OXFORDSHIRE COUNTY COUNCIL'S RESPONSE TO CONSULTATION ON THE FOLLOWING DEVELOPMENT PROPOSAL

Application no: 16/00864/REM-2

Proposal: Reserved Matters Application for 10/01642/OUT - Dorchester Phase 8 (Trident) only. The application represents the provision of 91 residential units of mixed type (dwellings and apartments) and tenure (open market and affordable) with associated gardens, access roads, car parking, landscaping, a local area of play (LAP), utilities and infrastructure.

Transport

REVISIONS:
A. 2016-08-10. Access road amended to address highway comments, parking spaces for plots 361-363 repositioned. DW

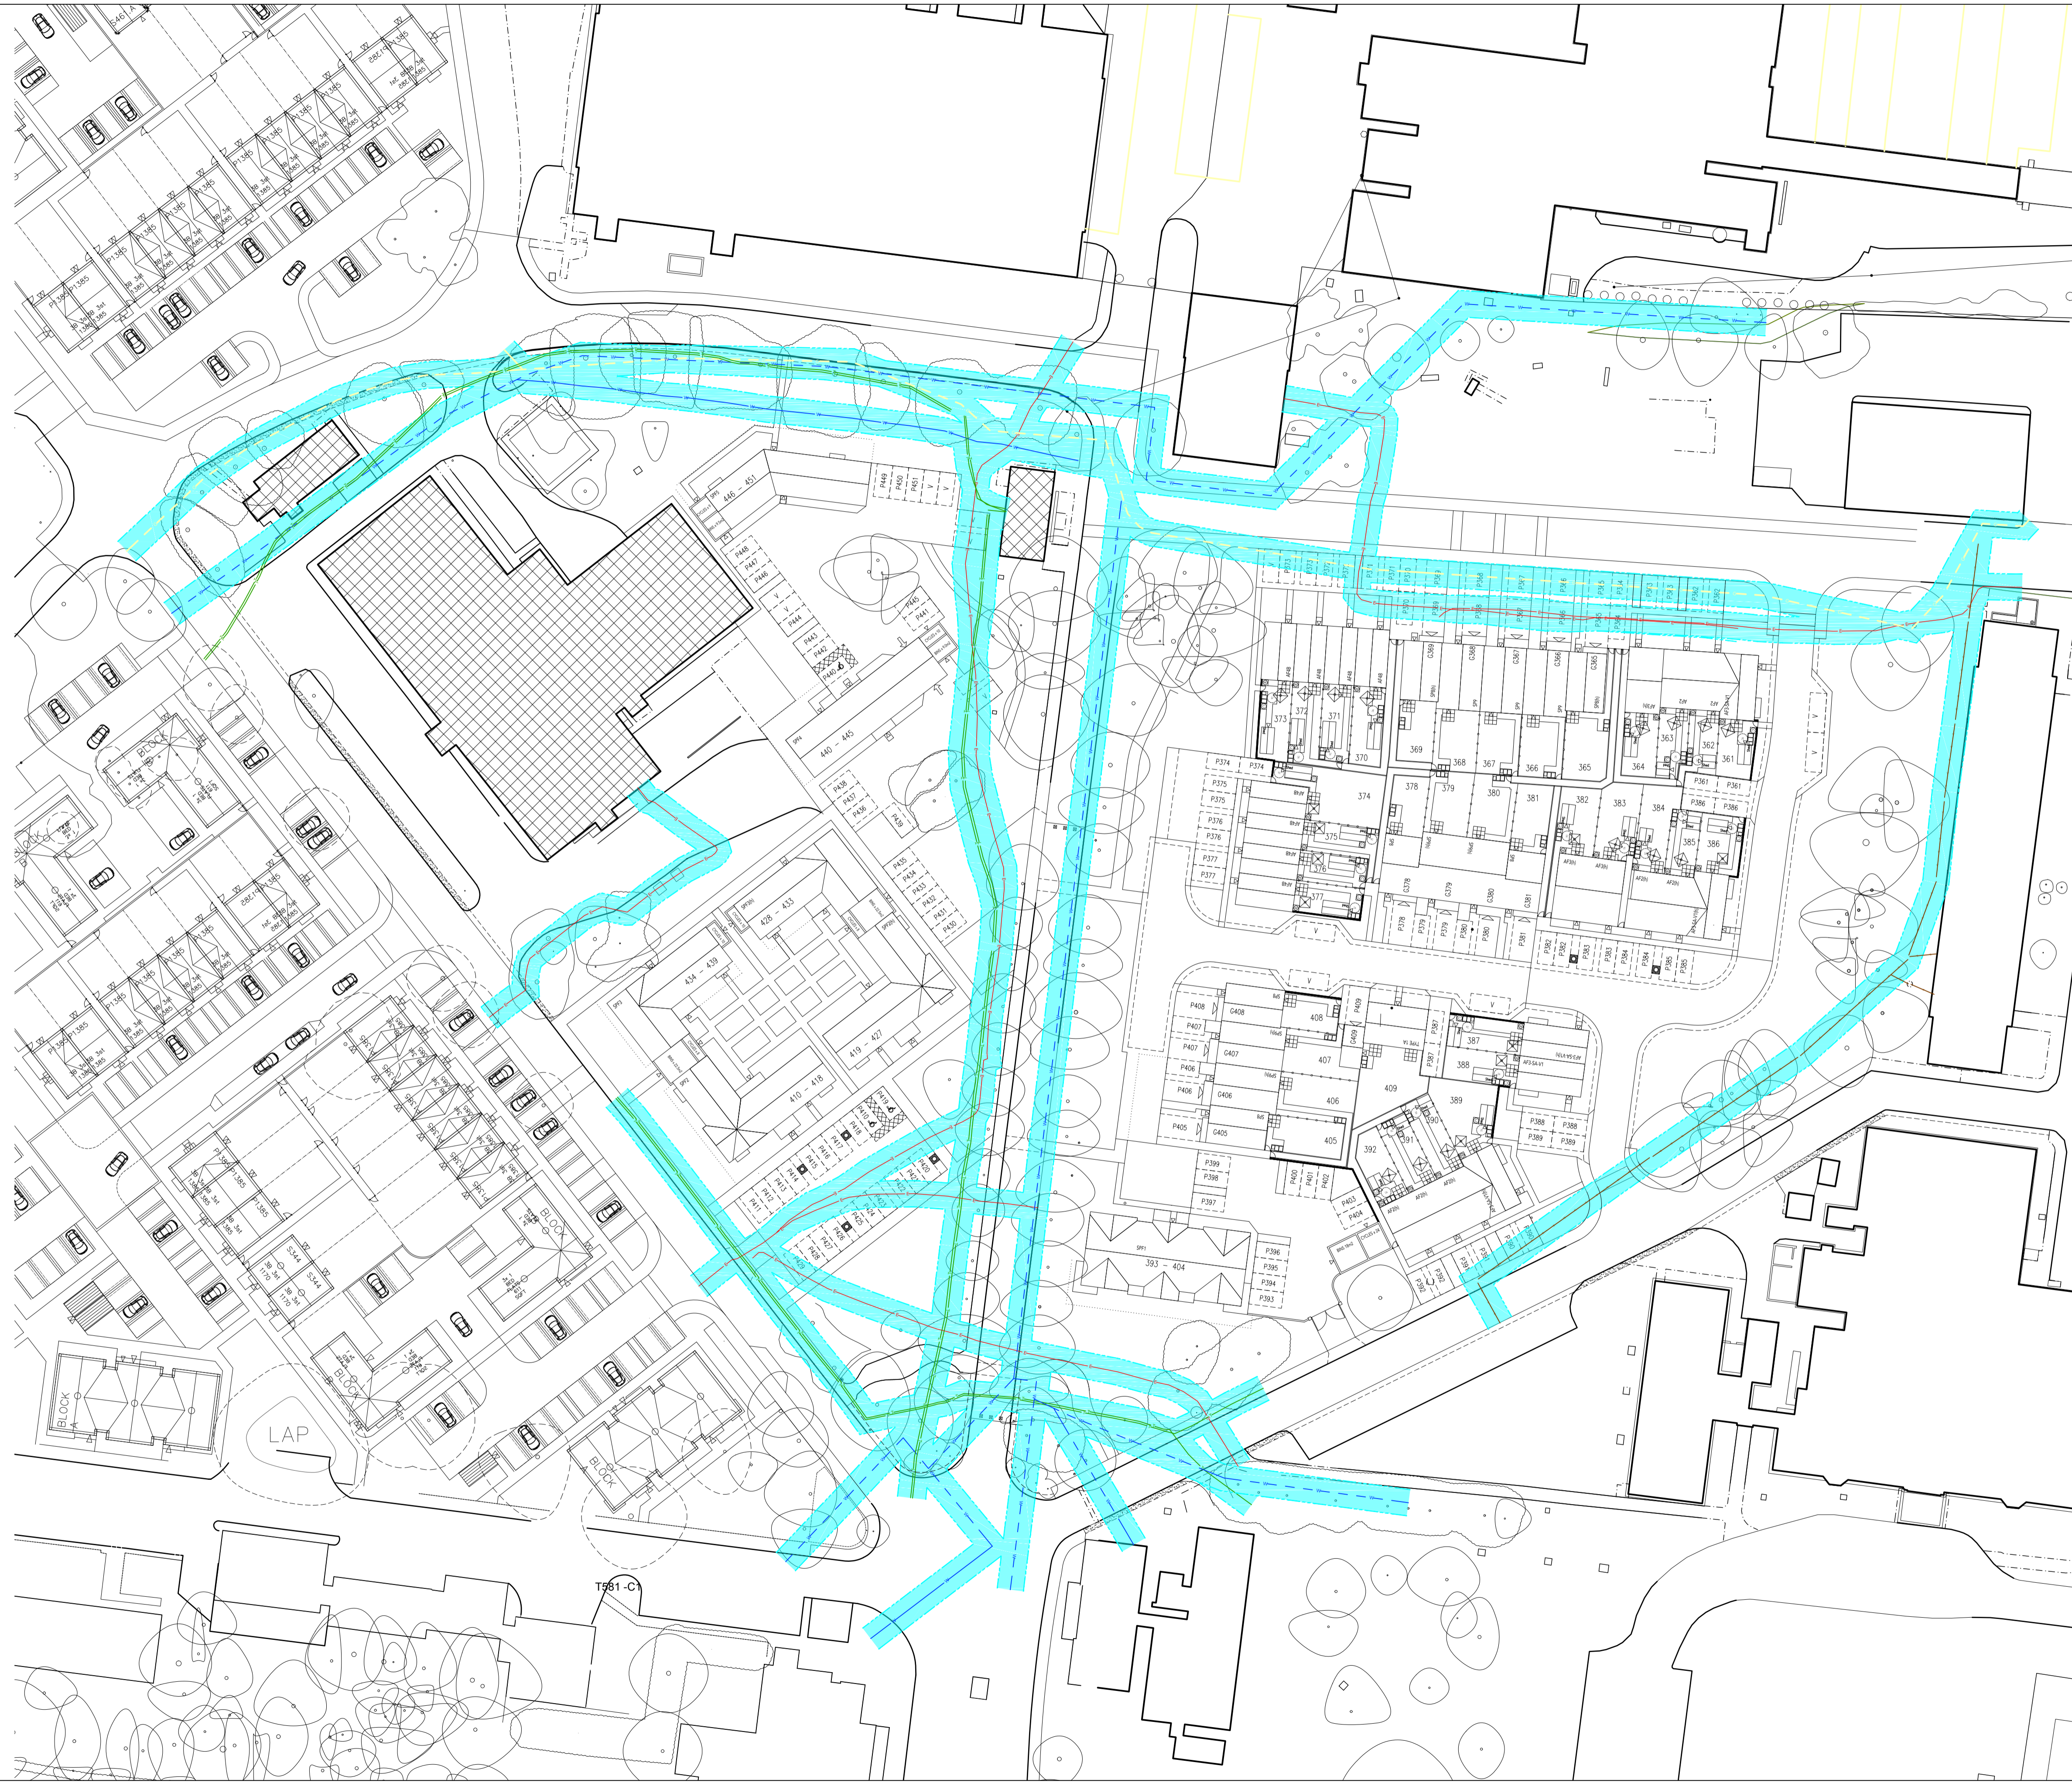
Insufficient deflection at the roundabout for traffic heading south down the straight middle road. Even if this road is not adopted, the roundabout needs to be safe.

There still seems to be a lack of sufficient traffic calming on the straight sections as noted in the previous OCC comments. **Reason for objection.**

On middle road, the key states private road except for cycles? Apparently this is possible but would need a clear cycle lane demarcation which is not shown.

It is assumed that the rumble strip is for traffic calming purposes. If this is the case then speed cushions are preferable. Ideally, not to have these straight sections and design in some natural traffic calming.

It is not clear if the footway issue has been addressed thoroughly. The red line boundary still does not seem to include the necessary footways or maintenance margins as stated in the previous response. This is most notable at the North and West of the site. **Reason for objection.**

Footway still terminates before the roundabout junction on the middle road. The roundabout is shown on the Highways plan but not shown on the External Works or Planning Layout drawings. **Reason for objection.**

Concerns regarding the existing trees still remain. There will be a need for root barrier protection to carriageway.

Street lighting of all adoptable areas still required, and is not shown on the plans.
